Change of use application from C3 dwellinghouse to C2
Residential Care Home and Regularisation of Outbuilding 2

Mistyfield House

Consultee Response 1

- **Applicant:** Jaiswal Property Developments Ltd
- **Agent:** Architectural Vision Ltd
- **Date:** July 23rd 2026
- **Consultee Response 1:** Response to Comments Raised by **Councillor Stefan McCrum**
- **Prepared by:** Architectural Vision Ltd on behalf of the Applicant.

Drawing Title
Site Plan as Existing and Proposed

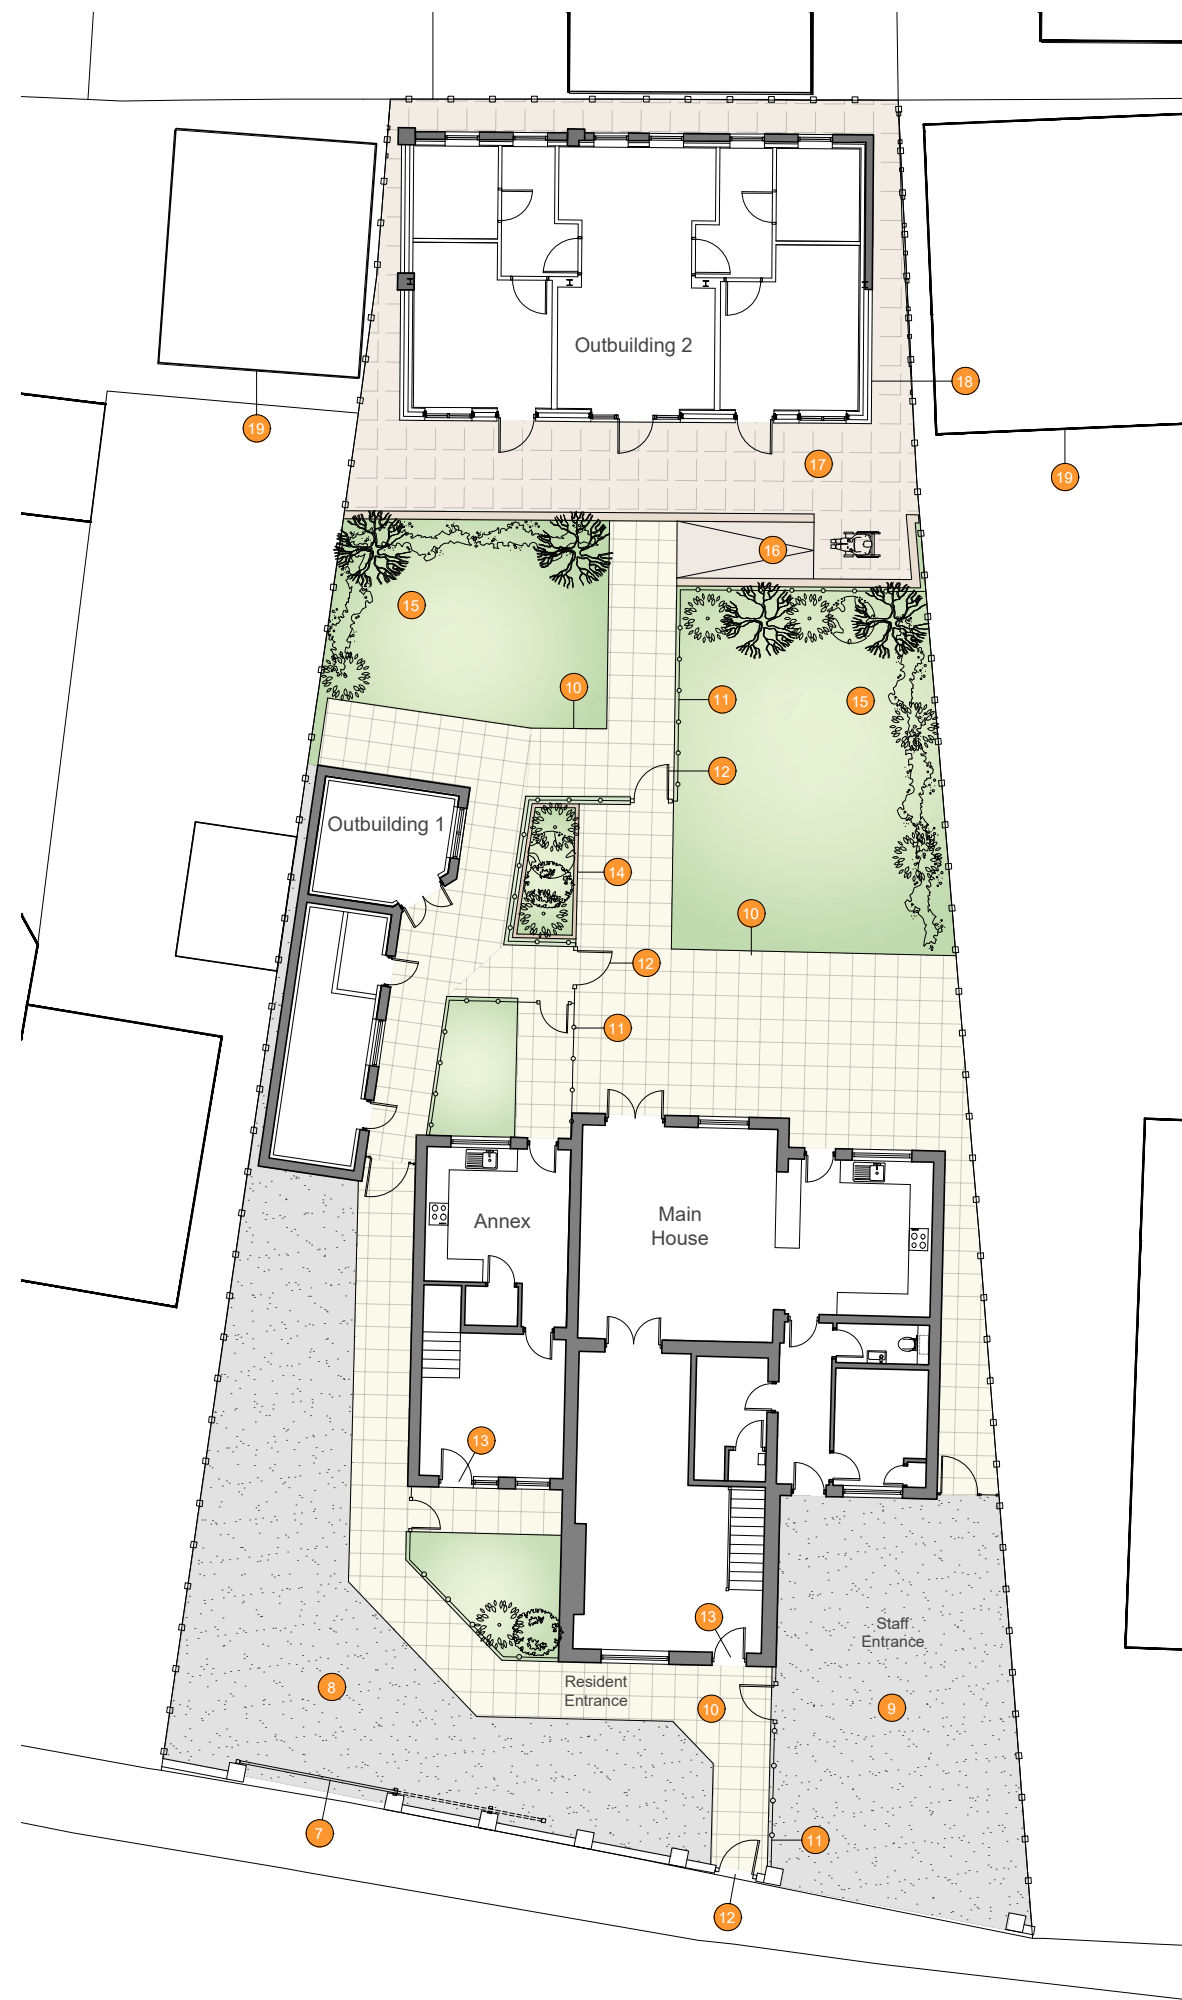
The concern has been raised that the site may not have suitable space for parking. In practice, the parking demand associated with the proposed use is expected to be comparable to, or only slightly higher than, that of the existing residential use of the property.

The site itself has ample capacity. The existing household currently parks four cars and two caravans on the site and already has space for up to seven cars. The two existing vehicular accesses and the generous gravelled areas to either side of the dwelling provide sufficient room for vehicles to enter, park and leave without difficulty. The proposed care home will not require any increase in the physical parking area of the site beyond what is already available and in regular use.

The future residents of the care home will not drive and will not own cars. Parking demand will therefore be limited to staff vehicles. The intended operator has confirmed that the service will employ a maximum of eight full-time-equivalent staff, with an average of six staff present overnight. Daytime staffing levels will vary according to residents' needs, but the overall number of vehicles associated with the operation is expected to remain modest.

In addition, the applicant intends to promote a Cycle to Work scheme and the use of public transport wherever practical, further reducing reliance on private cars by staff. Taken together, these factors demonstrate that the site can accommodate the parking demand associated with the proposed use without placing additional pressure on Church Hill.
